MP06_0310 Modification - Emirates Wolgan Valley Resort

Attachment A - Detailed NPWS and CPHR comments on Modification to MP06_0310 Emirates Wolgan Valley Resort

In providing these comments, NPWS and CPHR have reviewed the *Section 4.55(2) Modification to MP06_0310 Emirates Wolgan Valley Resort, prepared by de Witt Consulting, Rev001, dated 9 April 2026* (Mod report), and the supporting technical reports, including:

Figure 3. Preferred flight paths.

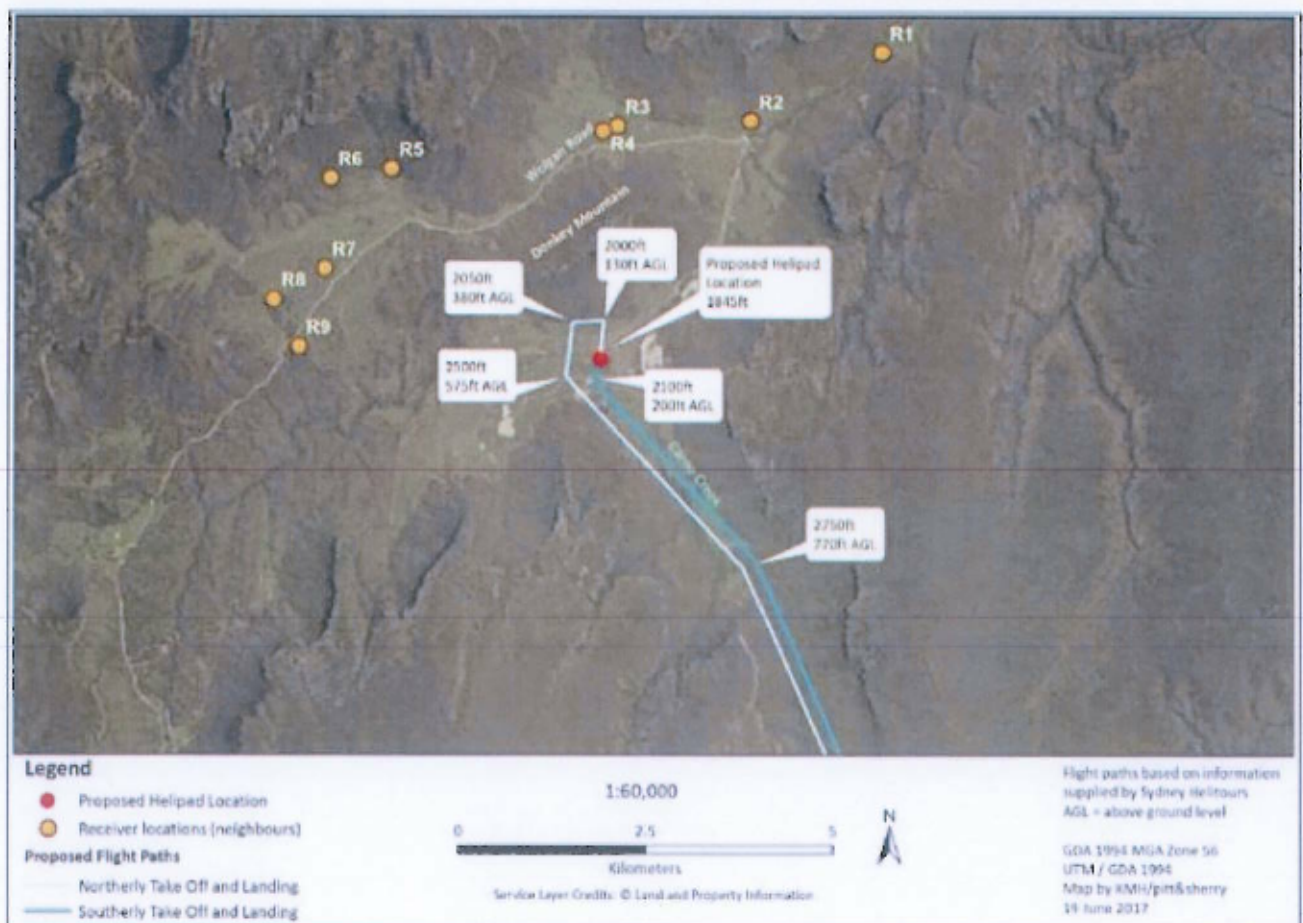
On review of the Increased Helicopter Trips Environmental Performance Audit as Appendix 6, NSW DCCEEW supports the revised flight path as the new flight path directly to and from the southwest to the operating helipad will avoid flying along the Carne Creek Valley. The proposed flight path required consideration of having the Final Approach Take Off (FATO) within the site of the resort, to and from the west of the helipad and beyond the FATO - optimising distances from existing residences to the north and achieving maximum altitude over the GoS NP to and from the south.

8. NSW DCCEEW confirms support for the revised flight path into the resort directly to and from the southwest of the operation helipad.
